**Subject:** RE: A/110/20/RES Land South of Water Lane Angmering Ap/17/OUT for the Bridge over the Black Ditch providing access to the approved development.

With regard to Planning Application A/110/20/RES further information has become available since I submitted my representations.

The EYA 2018 report contains 24 maps titled Case A, which is pre-development and Case-B, which is post development.

Figure 3.12: Case-B: Pre-development, depth map 0.1% AEP

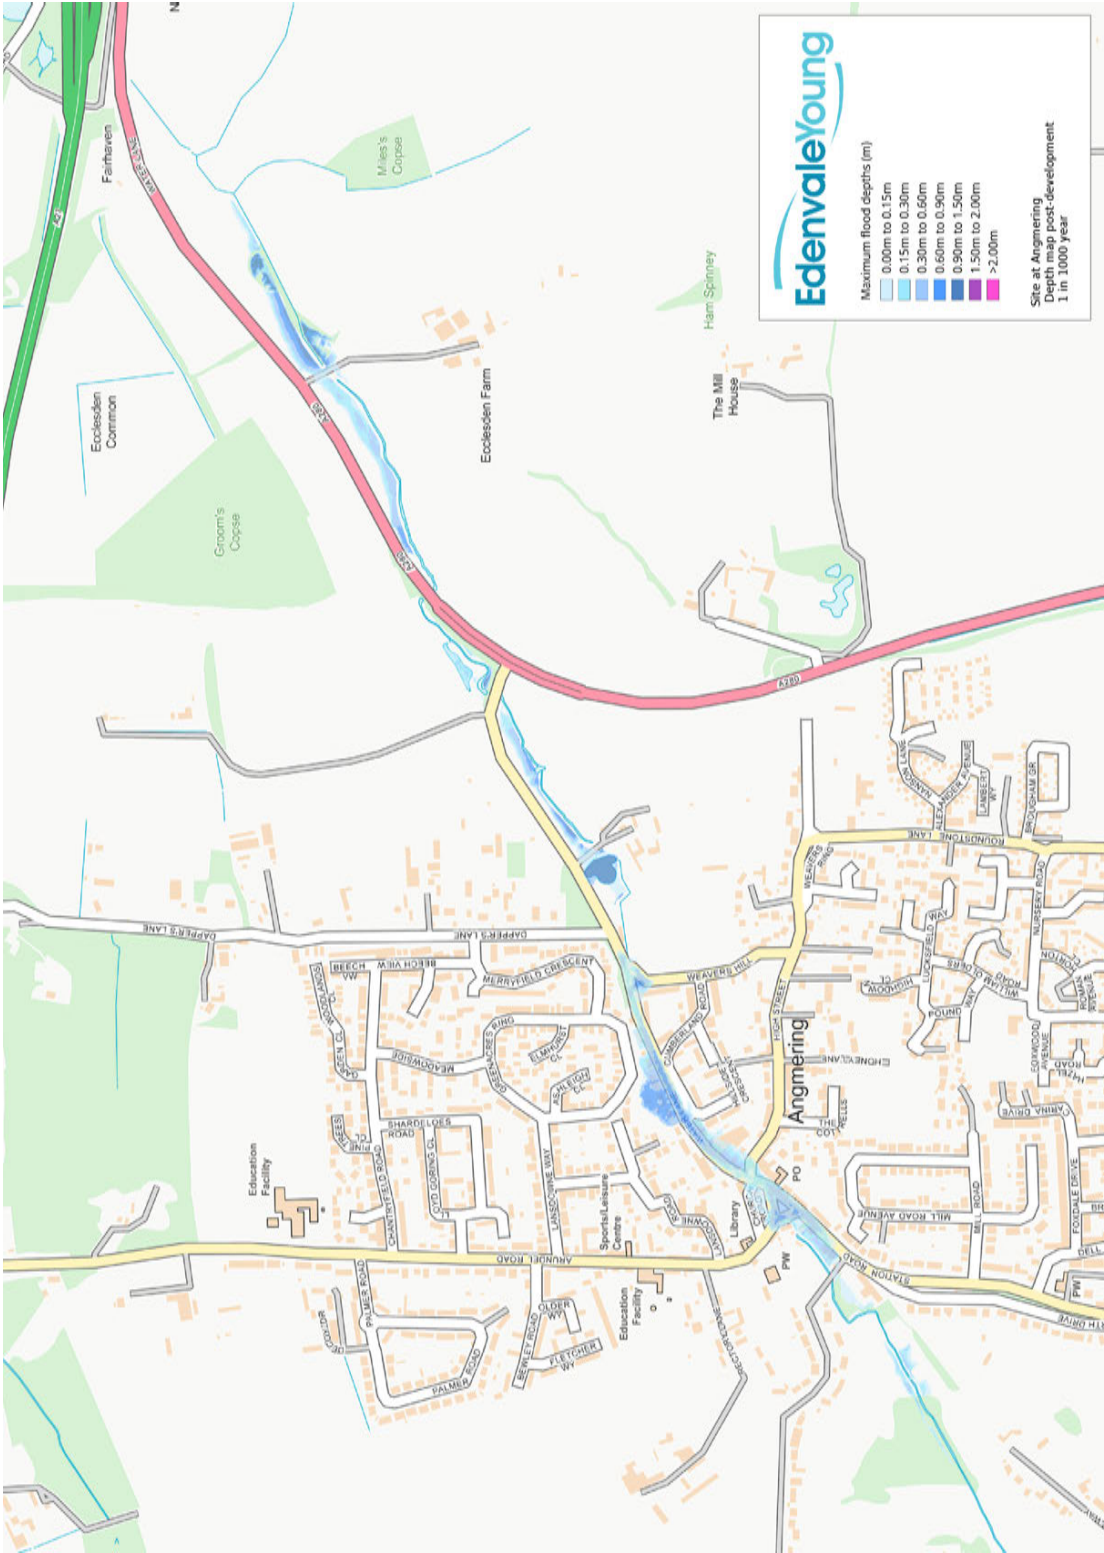
- The case B depth maps numbered 3.7 to 3.12 are headed 'Pre-development' when it seems they should be 'Post-development'.
- The case B level maps numbered 3.19 to 3.24 are also headed 'Pre-development' when it seems they should be 'Post-development'.

3.2.1 Case-A: Pre-development

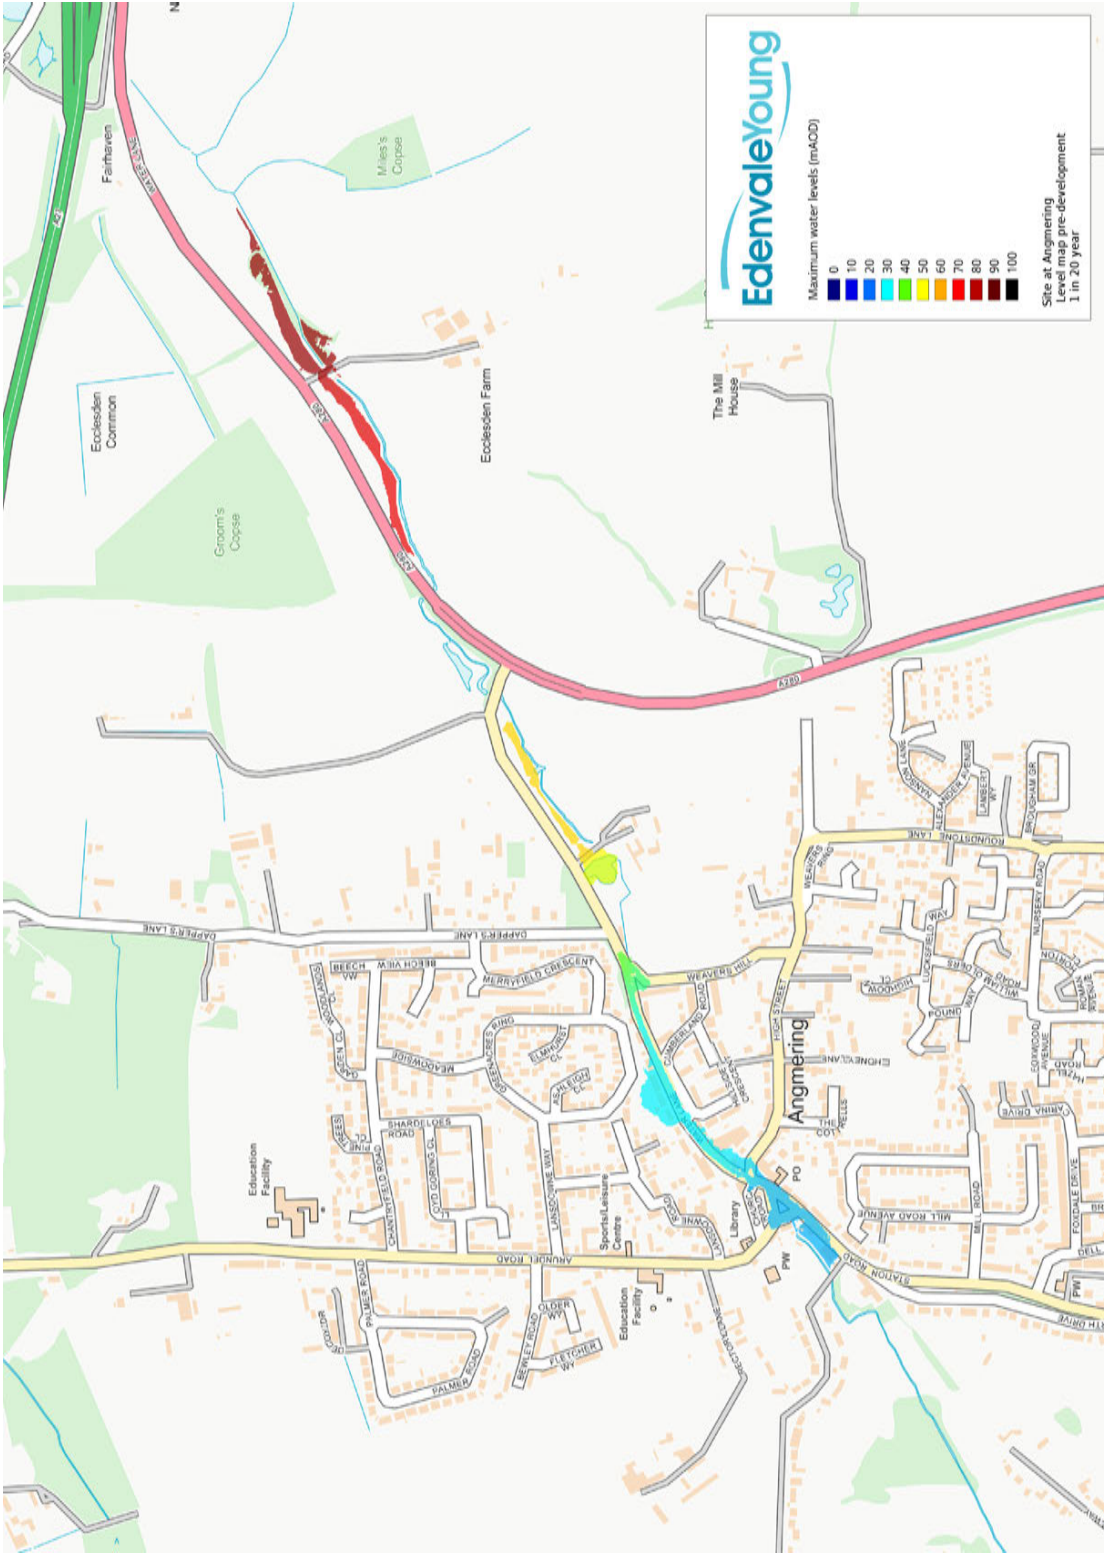
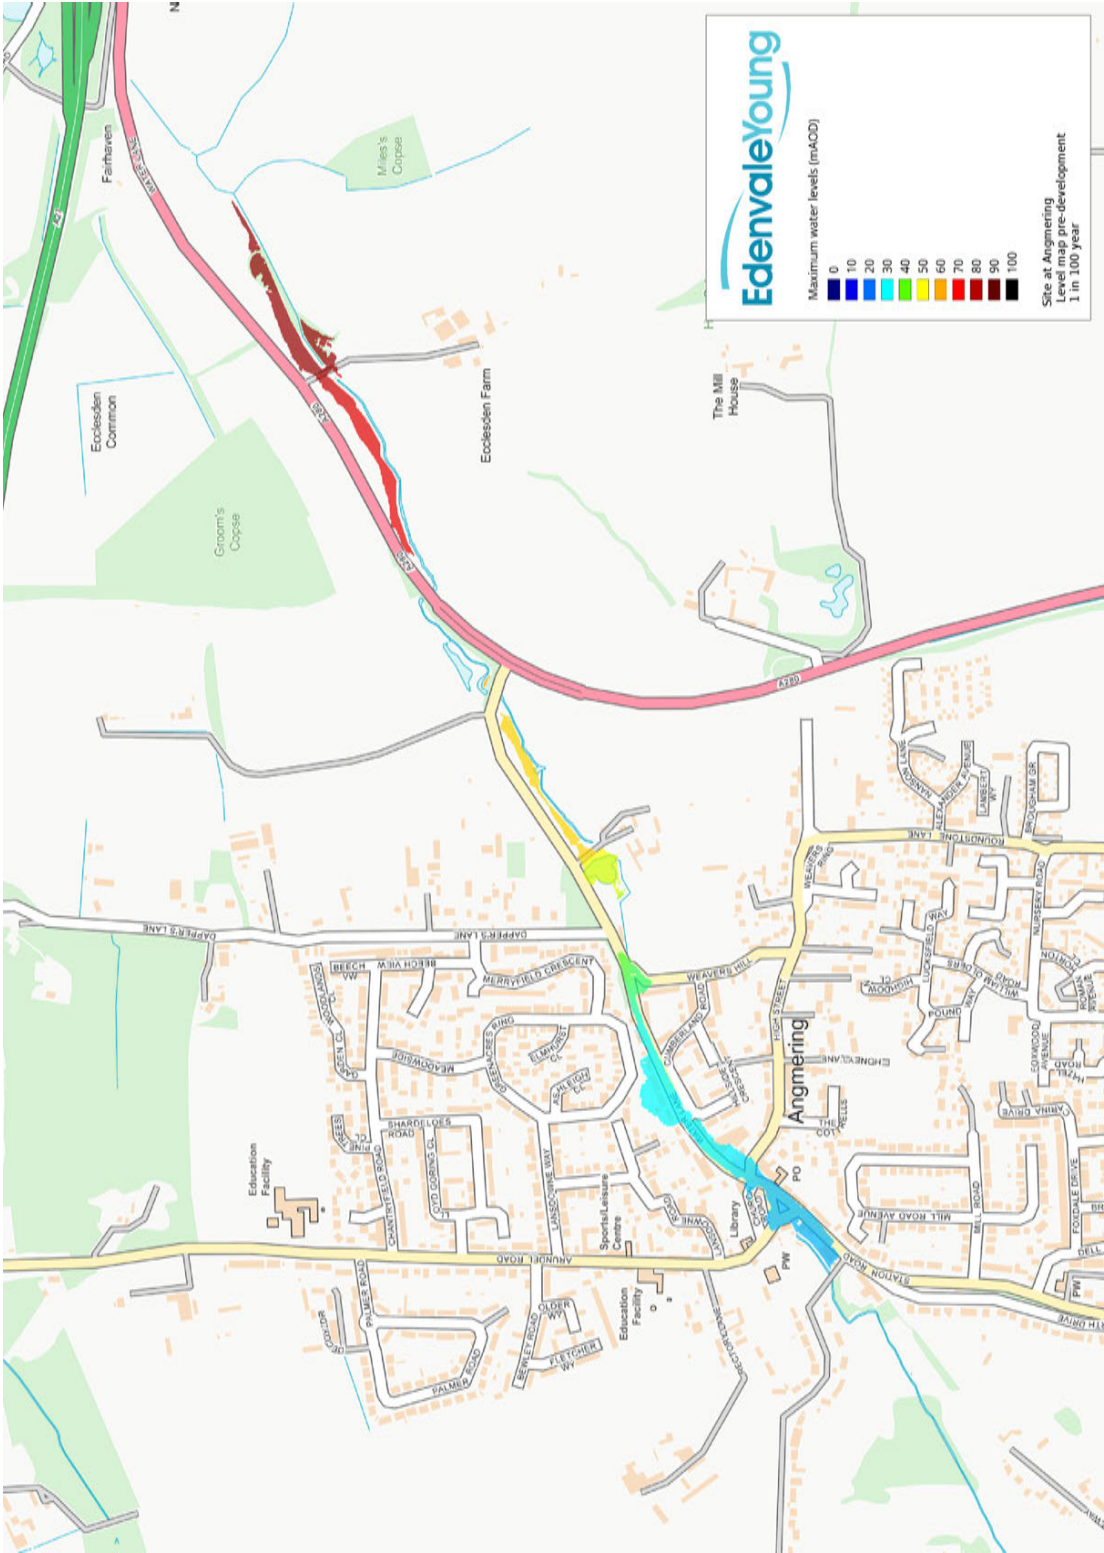
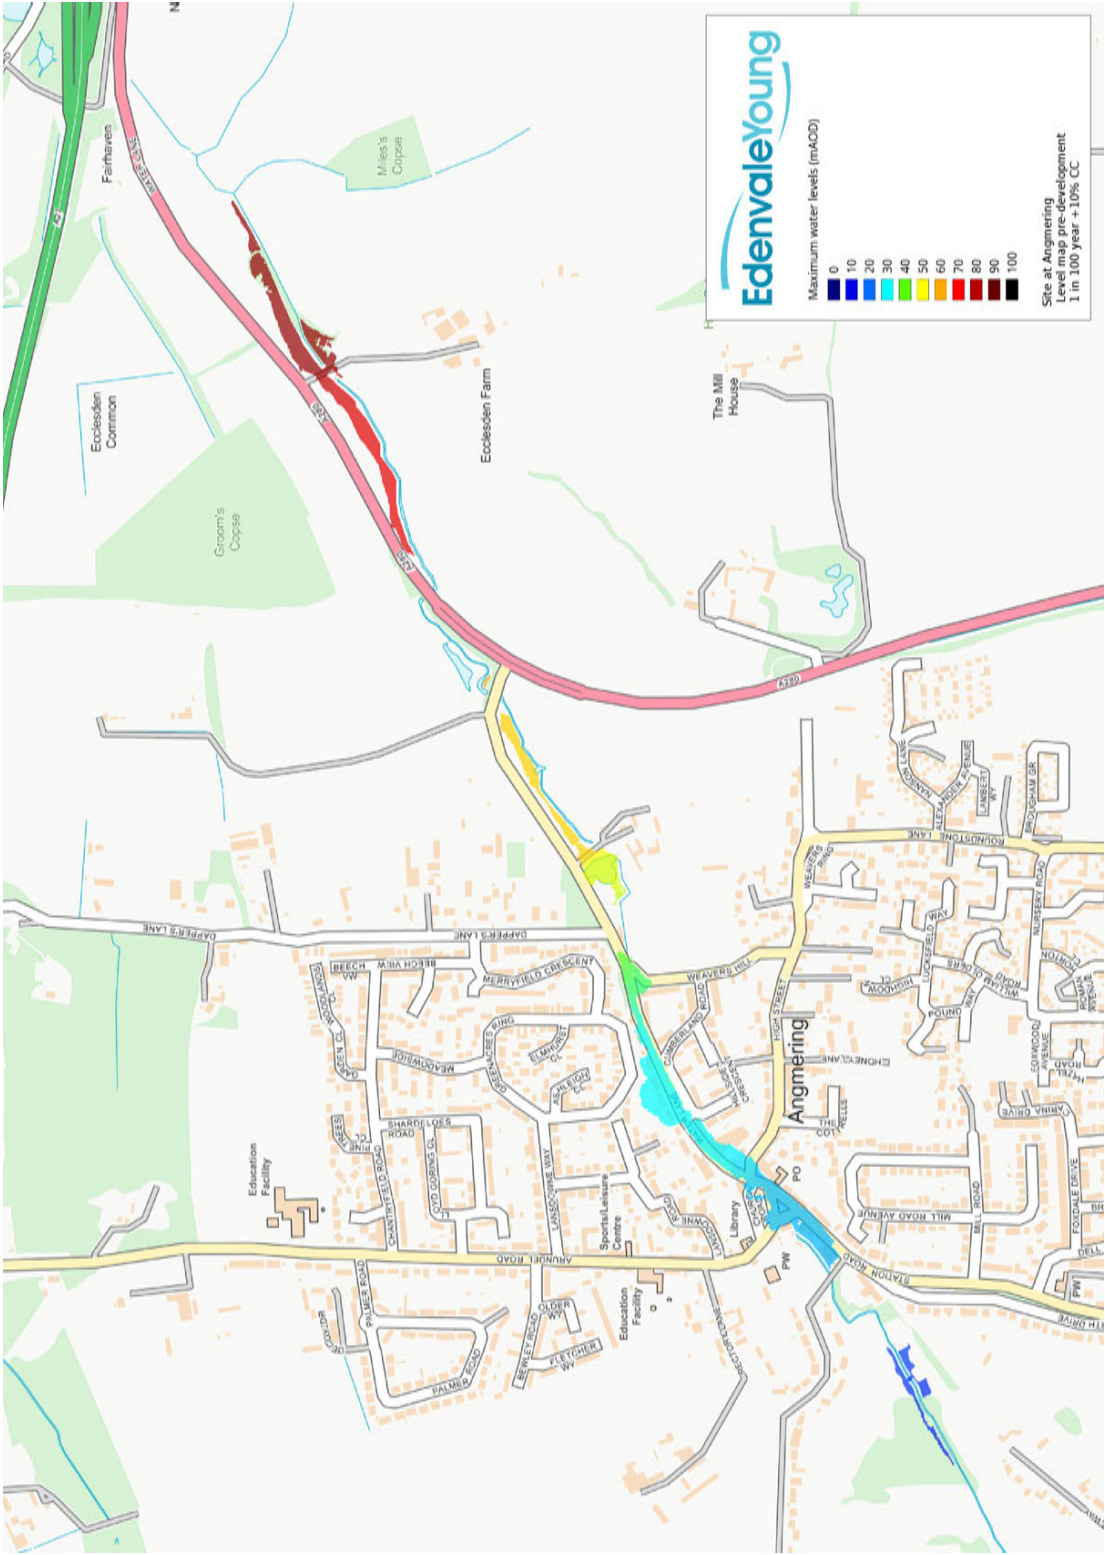
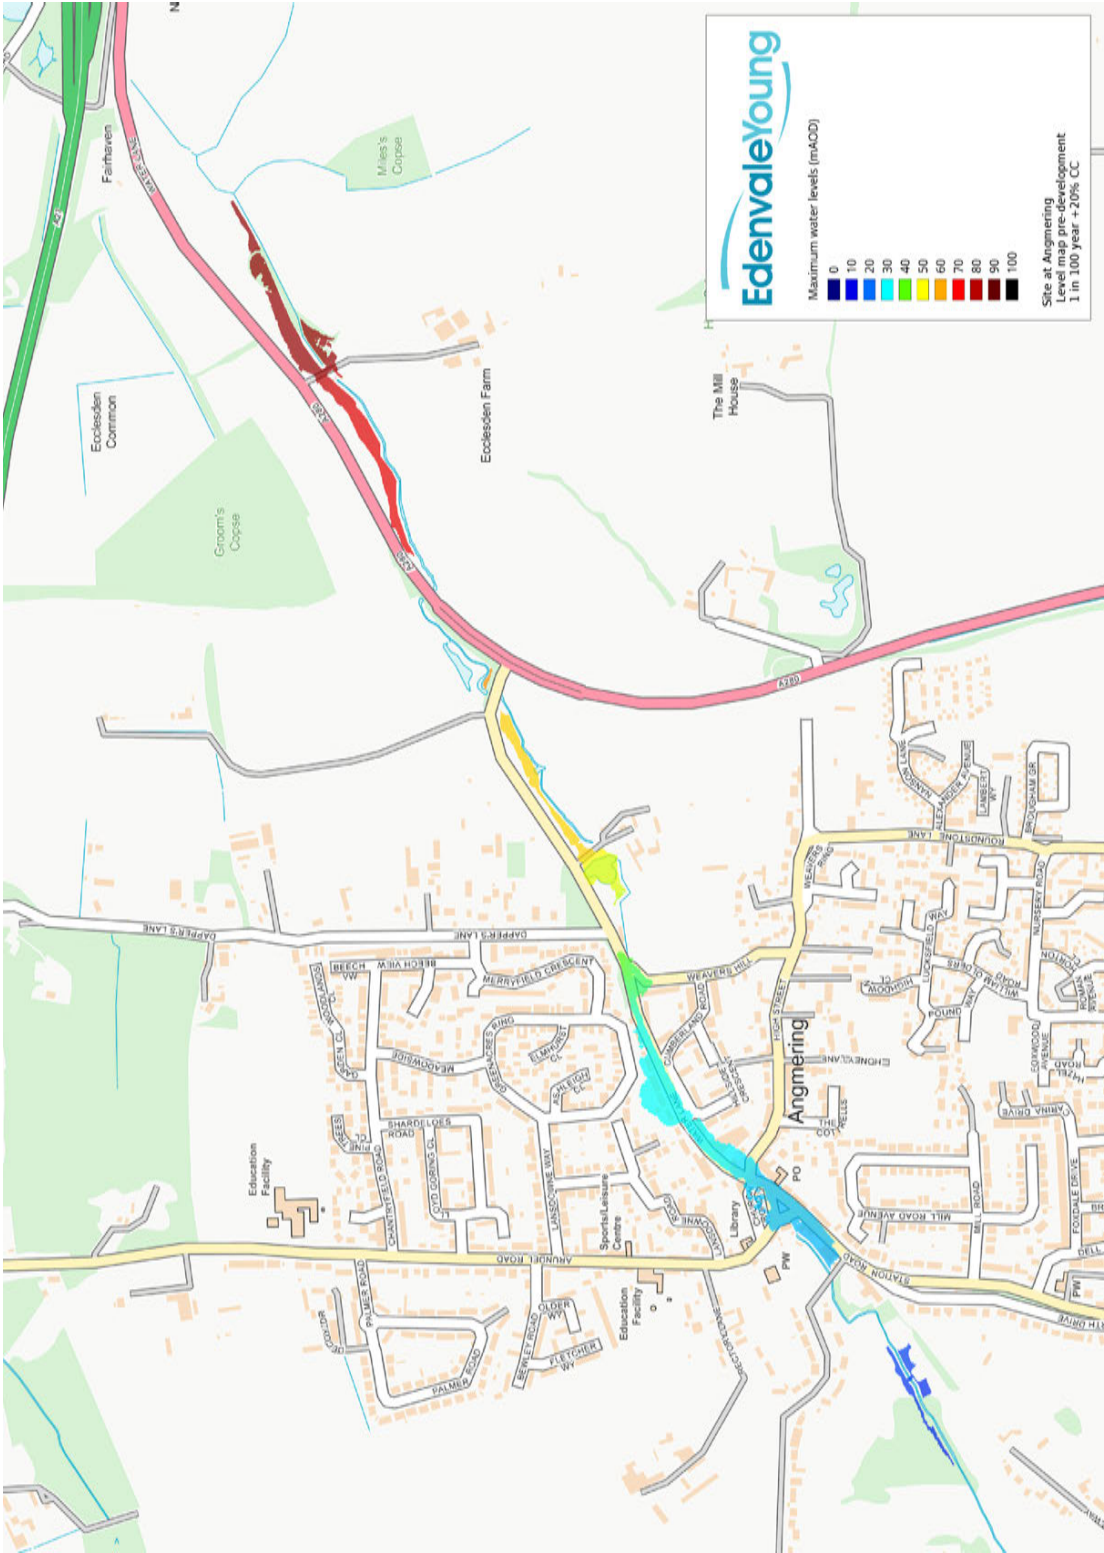
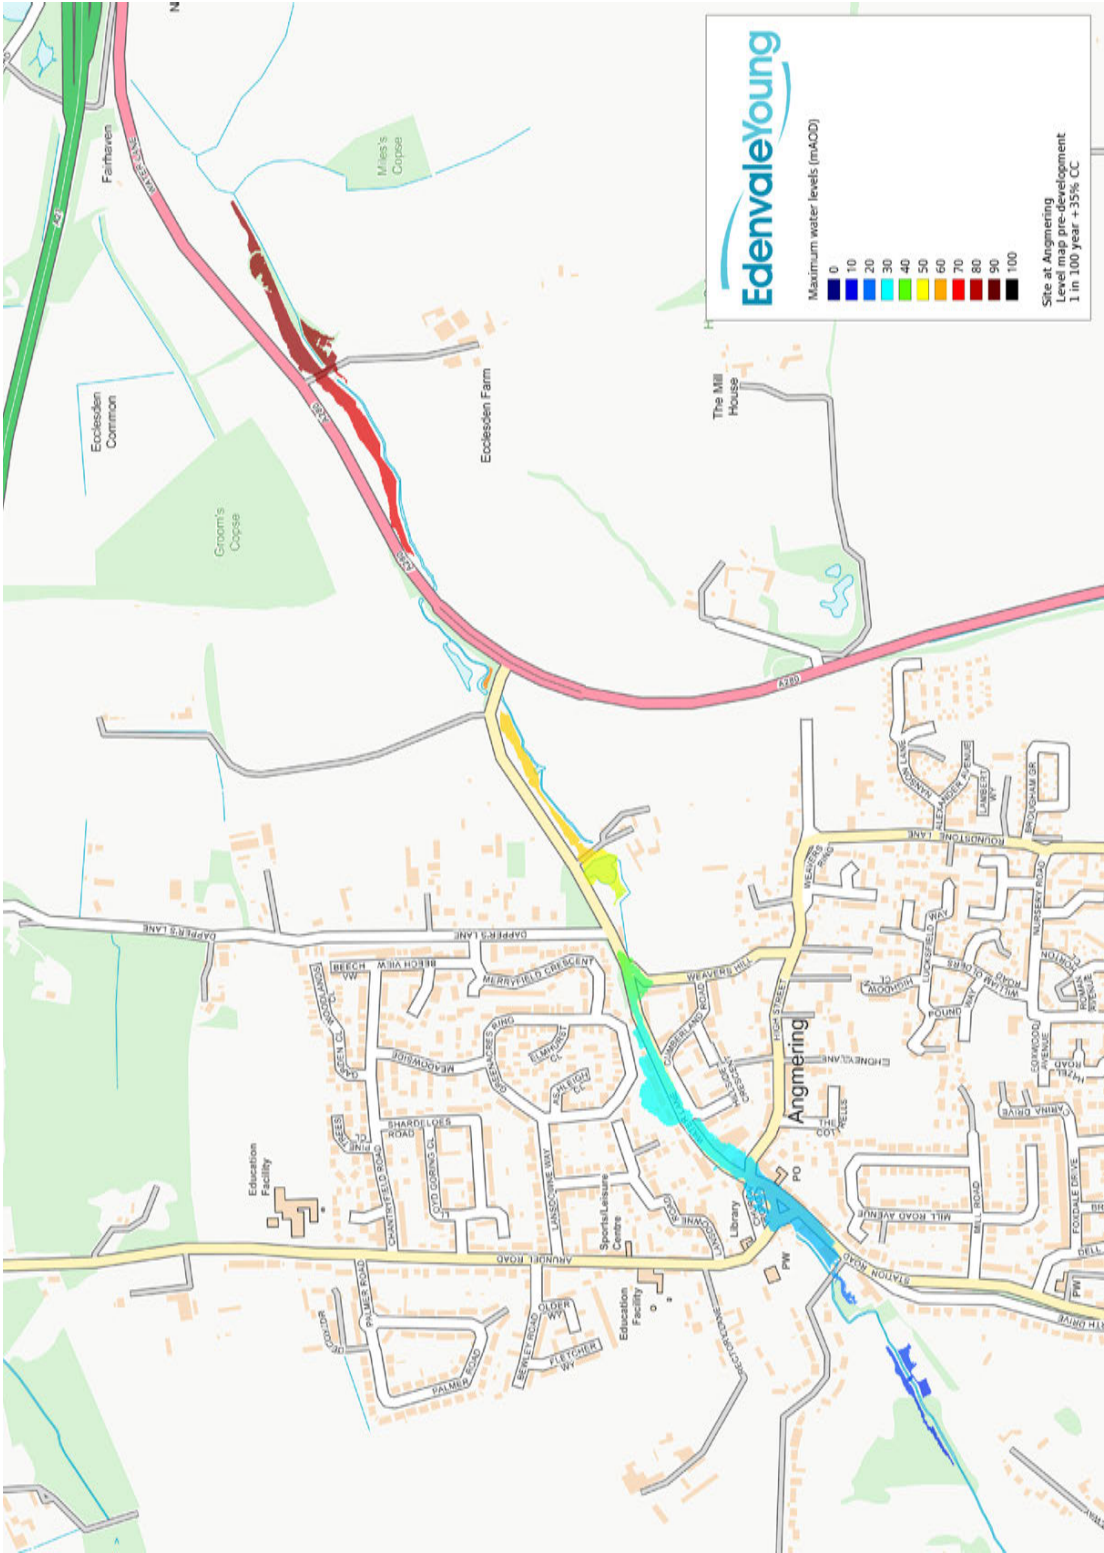
For example, the key to both the Case-A and Case-B level maps that describes 'Maximum water levels (mAOD)', and upstream of the Ecclesden Farm access the level is colour coded medium red corresponding to 80 metres AOD on the key, when we know that the top of Highdown is 81 metres AOD.
